Ref: 6/2015/1636/EM

Further to my letter of 15 September, I would like to add observations regarding the application under the Estate Management scheme.

5 Sherrardspark Rd
 WGC
 ALS TJW
 Proposed ~~new~~ extended driveway
 Front elevation.
 31.7.15.

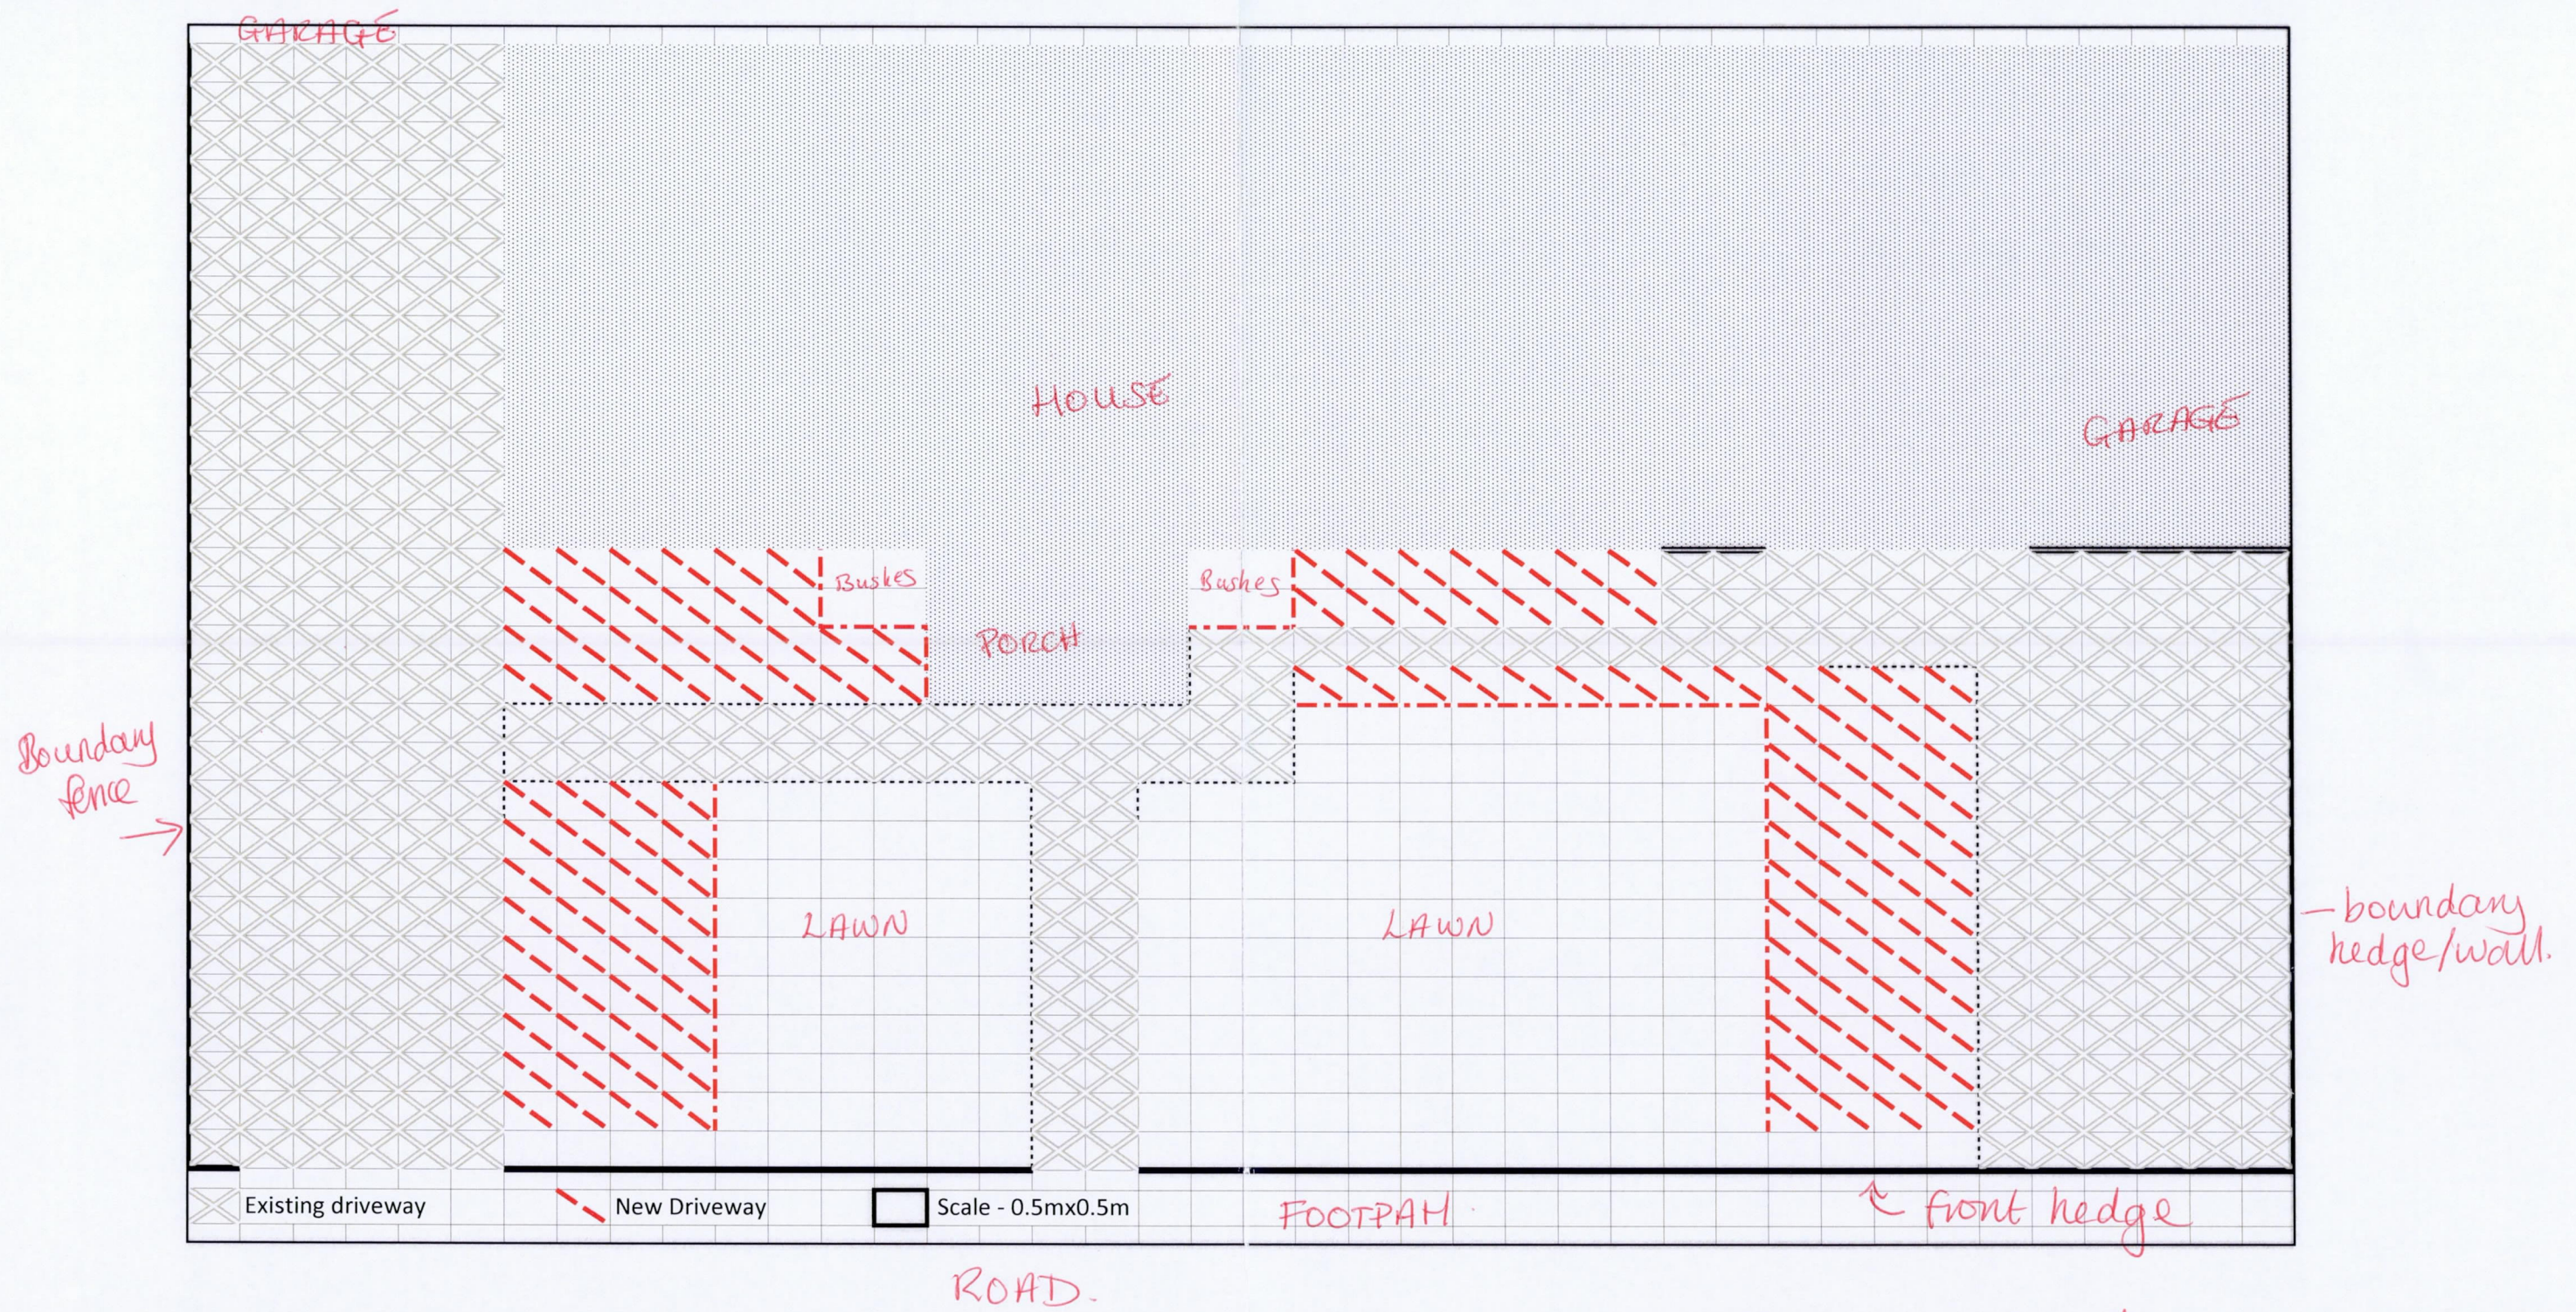
I have looked at the Estate Management Scheme leaflet in regard to hard and soft landscaping EM4 and I consider that the proposals exceed the 50% rule and detrimentally impact on the street scene and visual amenity. Other properties in the neighbourhood being part of the Welwyn Garden City conservation area have managed to combine hard landscaping whilst retaining sufficient soft landscaping to maintain this visual amenity.

The proposal is very stark, with only a small amount of grass and planting remaining.

I appreciate that the existing driveways are in poor condition, and could benefit from widening in front of the property by about a metre to allow access on hard surfaces but the proposals exceed this and would appear unnecessary. The property has two garages, one on the boundary with Scholars Mews set back from the road with a long driveway which can accommodate three medium size vehicles and another garage on the boundary with no 7 and has a driveway which is 20ft long and can accommodate one further vehicle. This seems in keeping with properties of a similar size in the neighbourhood. The current parking restrictions in the road are the nominal "9-11" which exist in the area and have done for some 15(?) years.

The drawings I was given do not show what materials will be used in the scheme and how much digging will be required. As you know I am concerned that the boundary/retaining wall needs to be maintained to prevent collapse of my hedge, border and path to my main entrance.

I cannot see the benefit of removing the planting along the front of the property and leaving two small pockets adjacent to the large porch. Retaining planting, even in a narrower border would be desirable to keep the feel of the "Garden" City.
